Re: **Bradley Heights PUD Development Plan- Filing 1 & 2 – File # AR PUD 21-00206 – Responses to 1st Round Comments**

We are in receipt of your review letter dated May 13, 2021. Below is a point by point response to these comments prepared in coordination with the Developer (Challenger Homes) and the Design Team.

TYPICAL LOTS

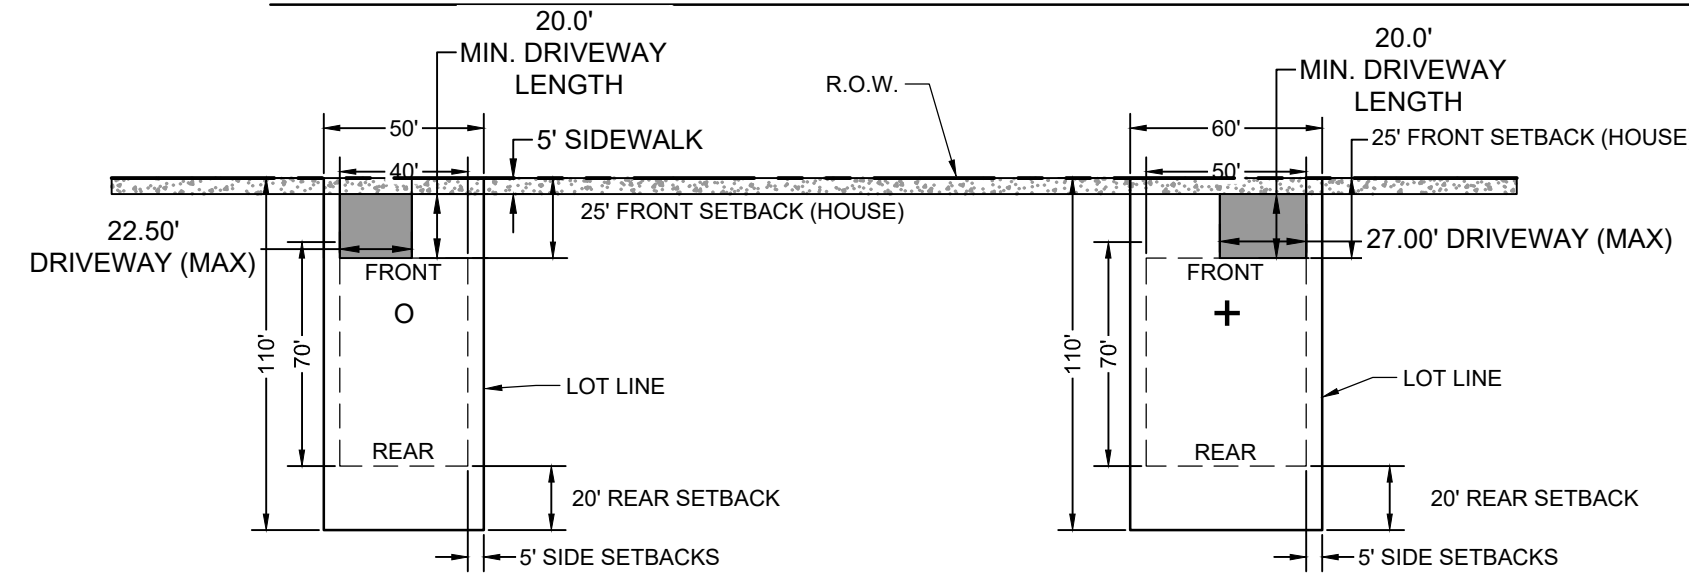
11. Clarify what amount of front (or rear) yard area can be covered by driveways, for each type of lot. See City code section 7.4.206.E.2.:

- (1) On lots with widths (at the front setback line) of less than seventy five feet (75') no more than forty five percent (45%) of the required front yard, as measured from the front lot line to the front setback line, shall be used as driveway or parking area.

6. Please provide a typical lot layout including proposed easements and proposed service lines with proposed gas and electric meter locations.
HR Green Response: Addressed, a lot typical with service locations added to utility plan.

HR Green Response: Addressed, lot typical updated to indicate a maximum of 45% lot coverage in the front yard.

**CUSTOM COLLECTOR -
BRADLEY LANDING BLVD.**
NOT TO SCALE

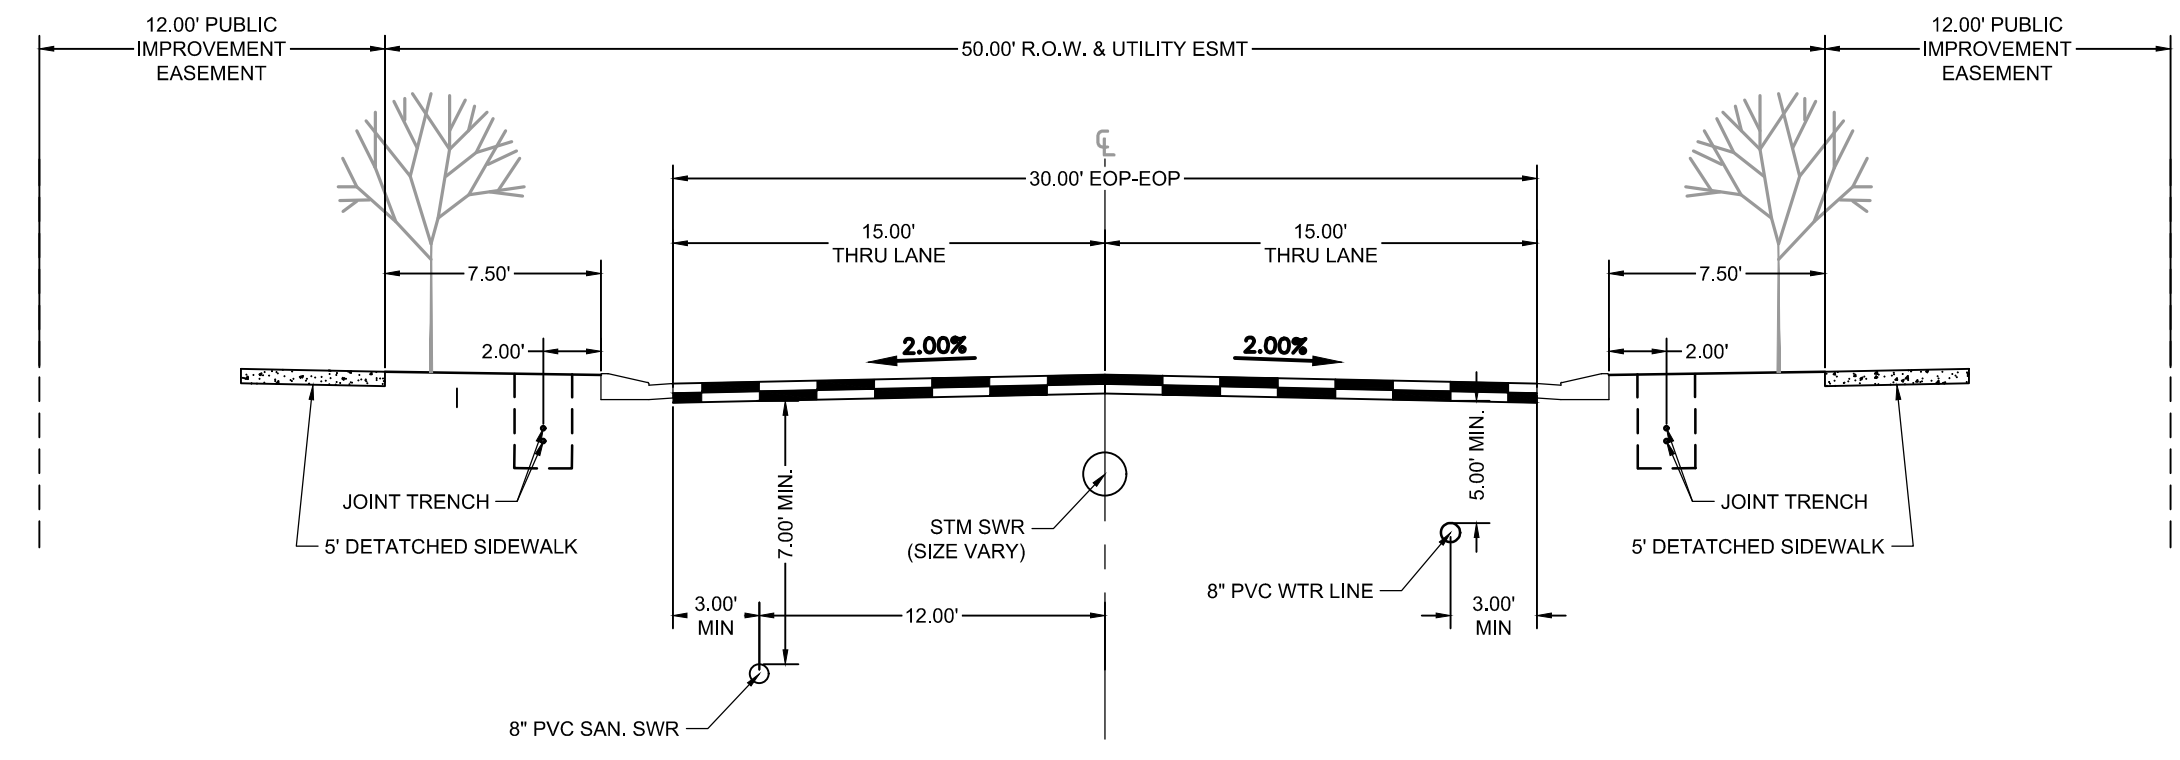
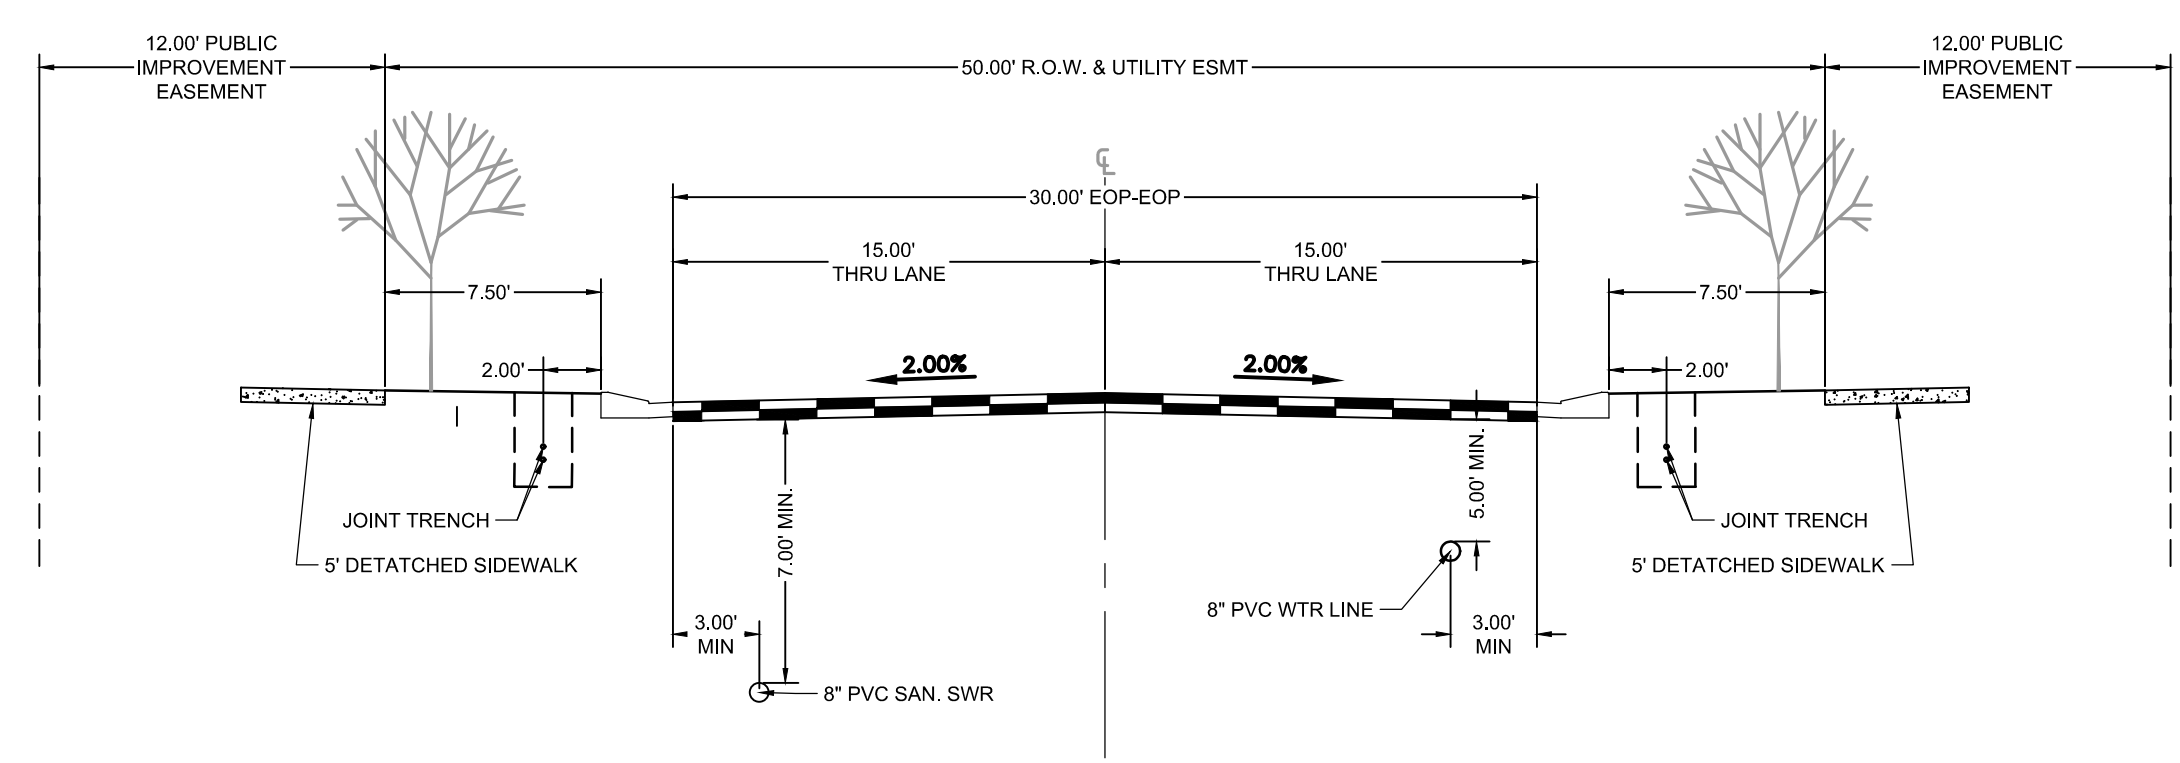
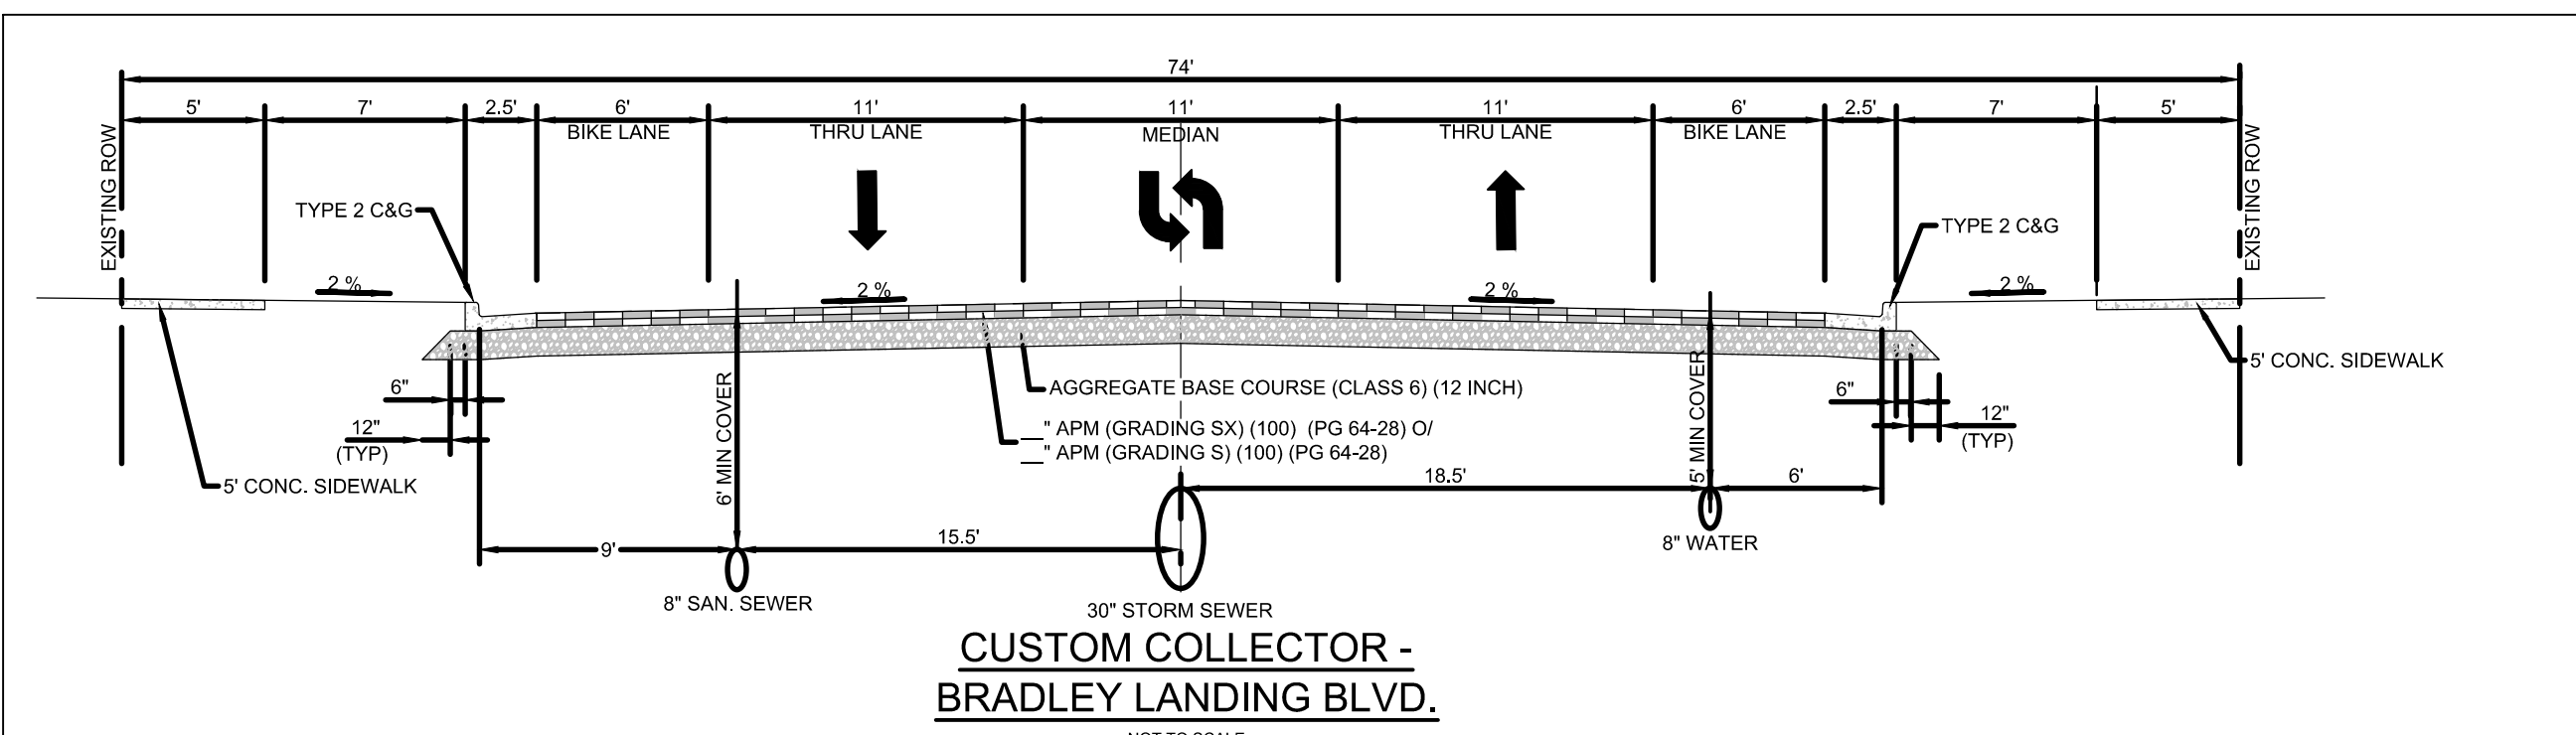
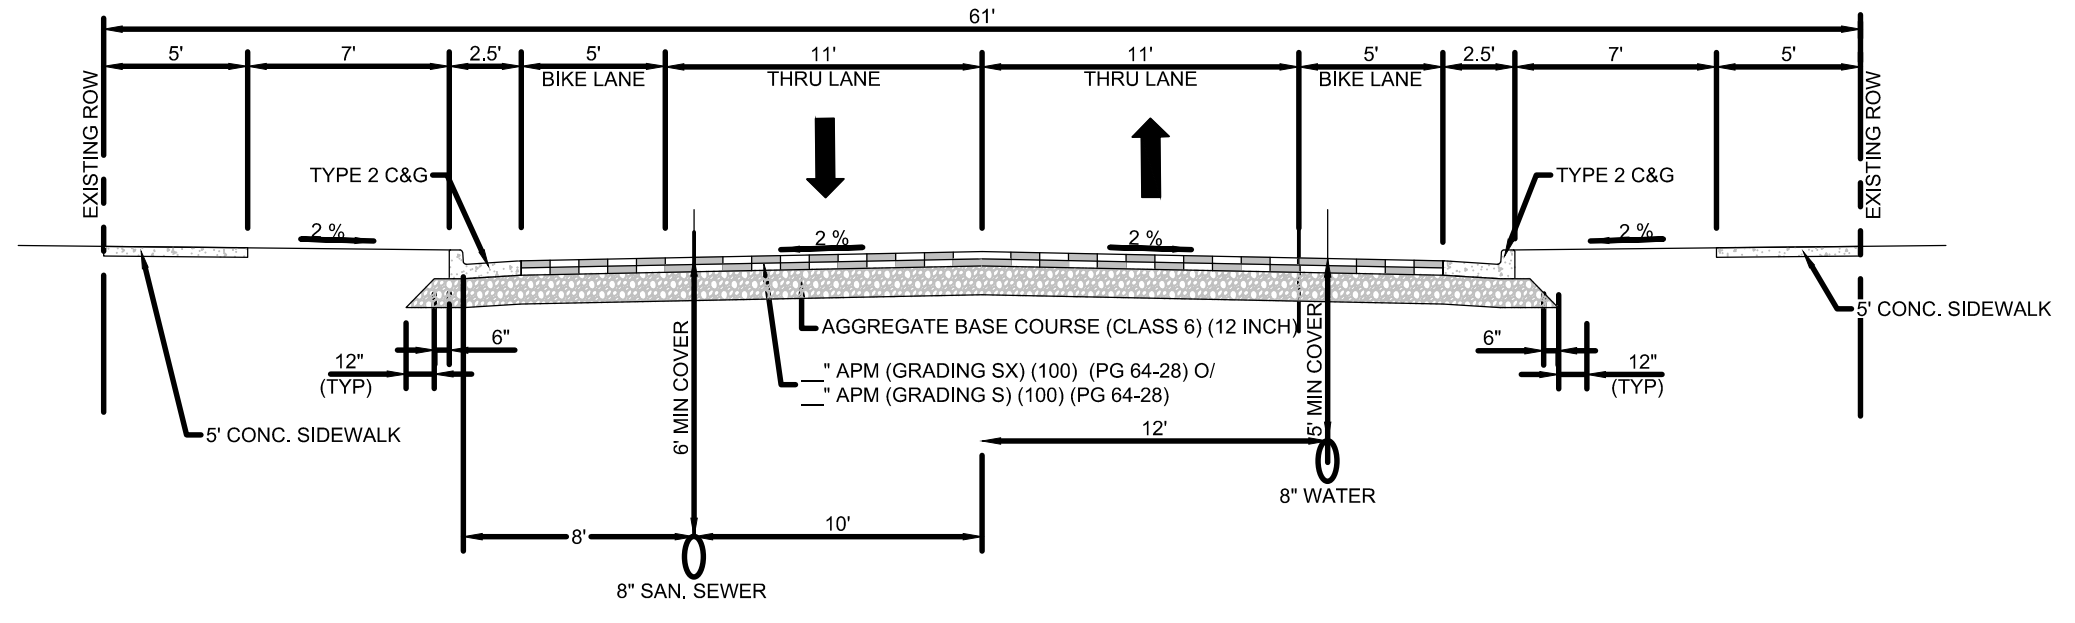
2. On Sheet 2, the residential and collector cross-sections. The joint gas and electric trench is now under the sidewalk. Update the cross-sections. Typical street cross-sections can be found in City Engineering's standard details. Include a cross-section for the Bradley Landing Blvd (Minor Arterial).

2. Please provide a cross section.

HR Green Response: Addressed

HR Green Response: The Bradley Landing Blvd cross section (as proposed by the Bradley Heights Metropolitan District) has been added to added to Sheet 2.
